Project:	Pearl Place II
Location:	Portland, ME
Becker Job No:	2569

OBSERVATION REPORT

Cast in Place Concrete

Observation Location: Pile Cap/Grade Beam Reinf Line 1

TITLE: FOUNDATION SECTIONS AND DETAILS

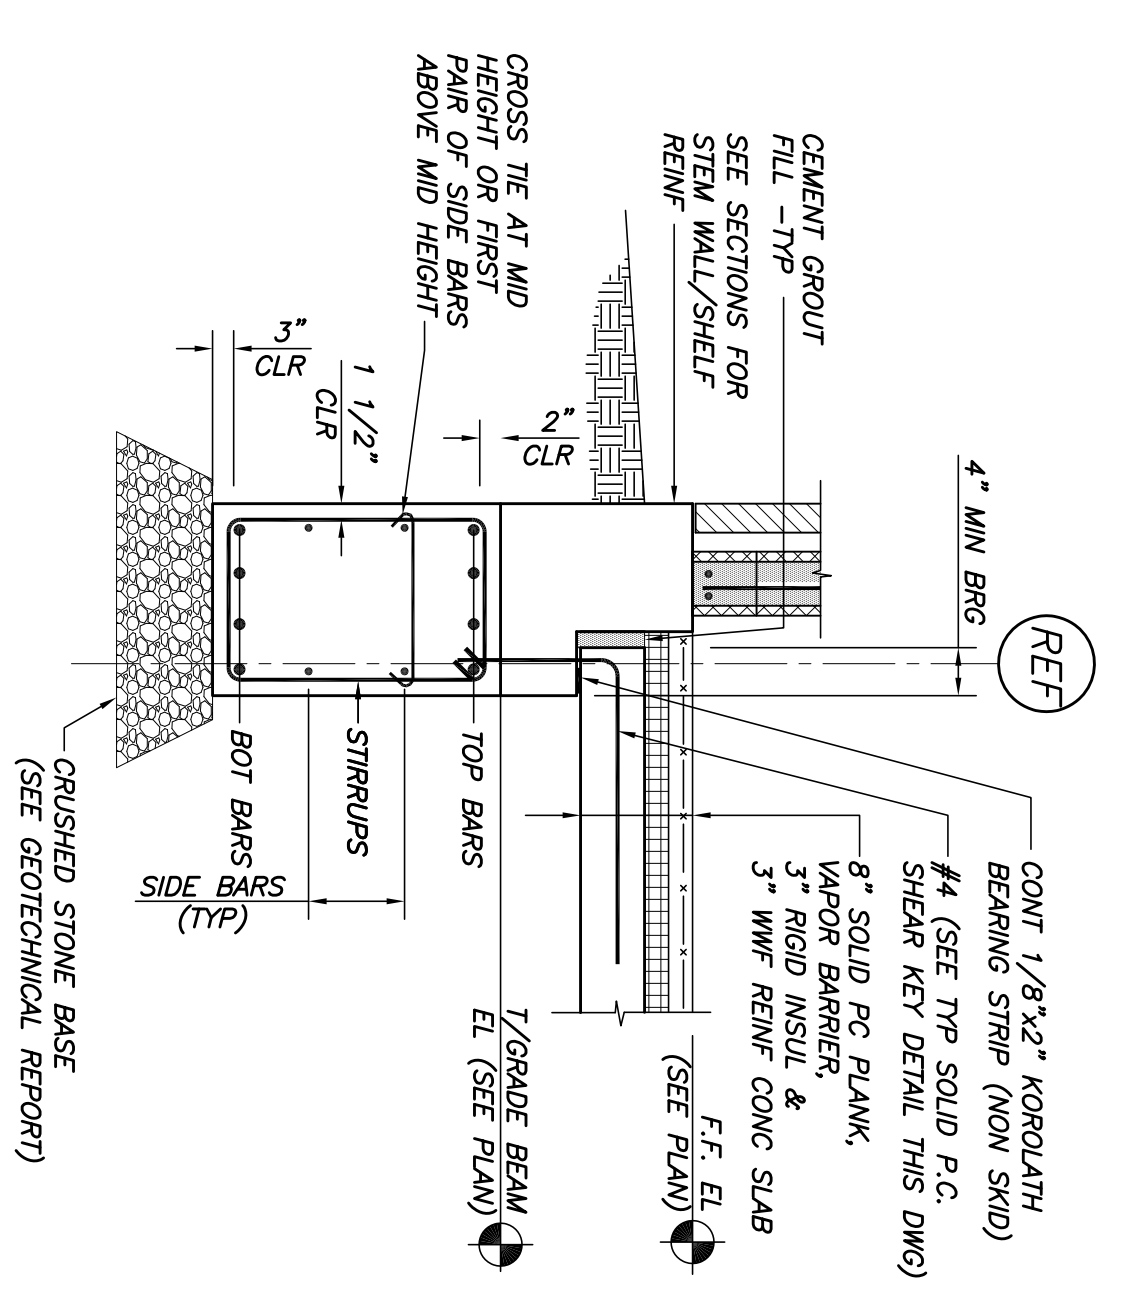
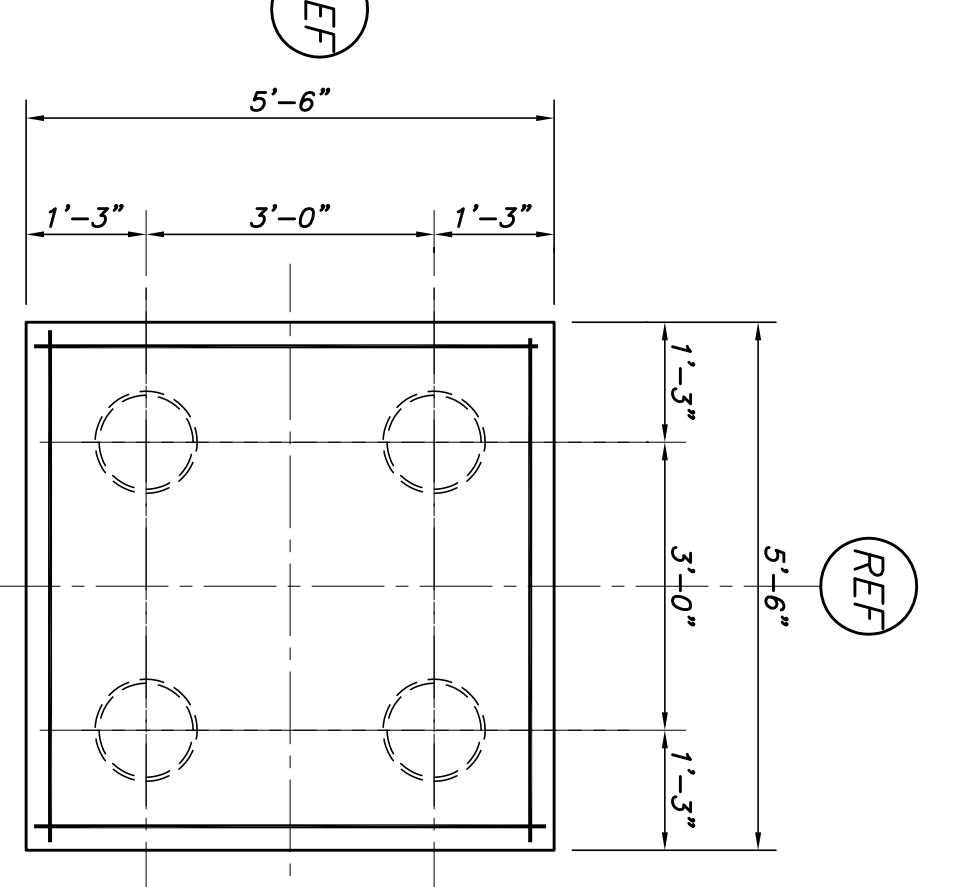
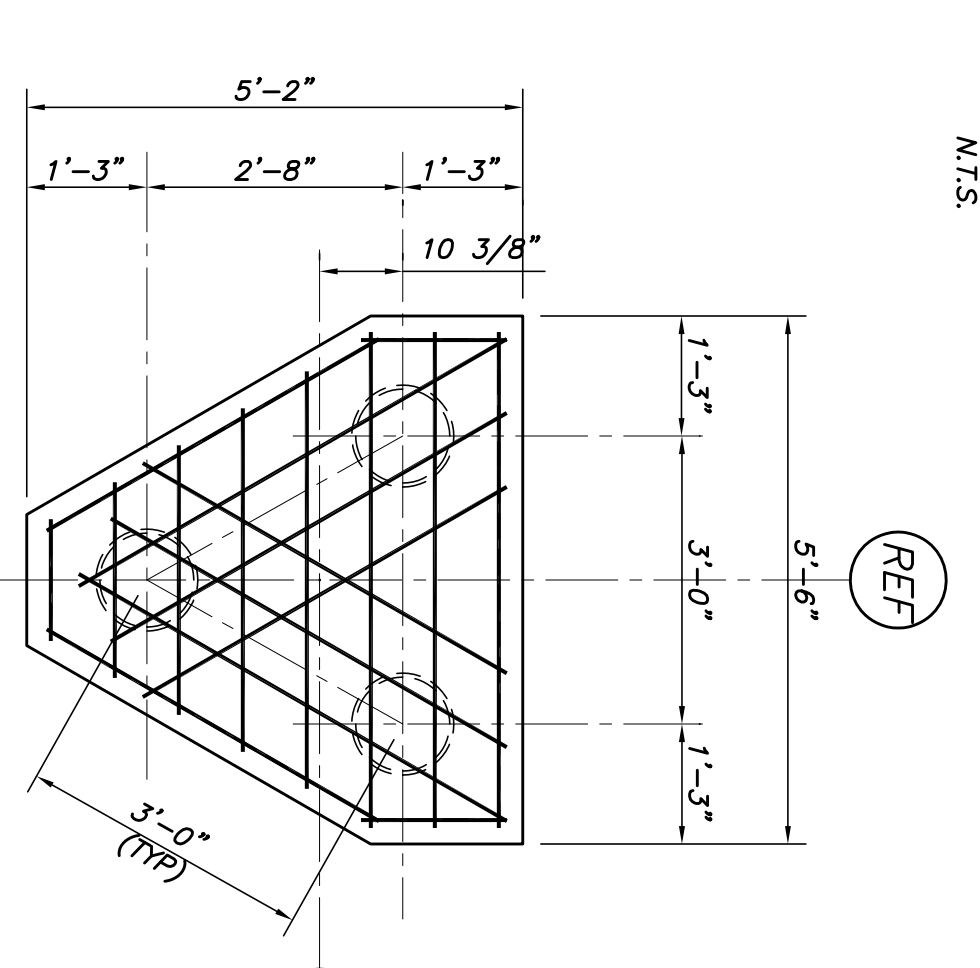
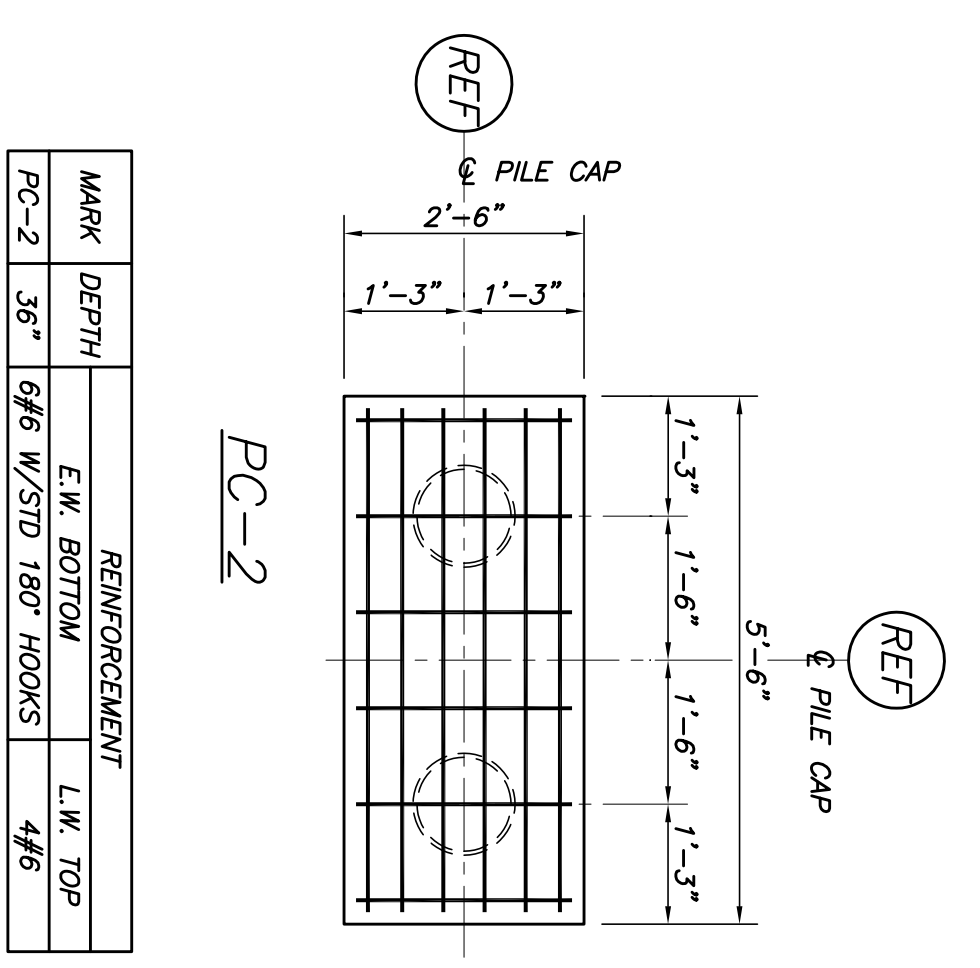
Incorrect reinforcing per CSKS-2 observed in bottom of grade beam. Reinforcing difficult to observe to due snow build-up, follow-up visit scheduled for 2/1.
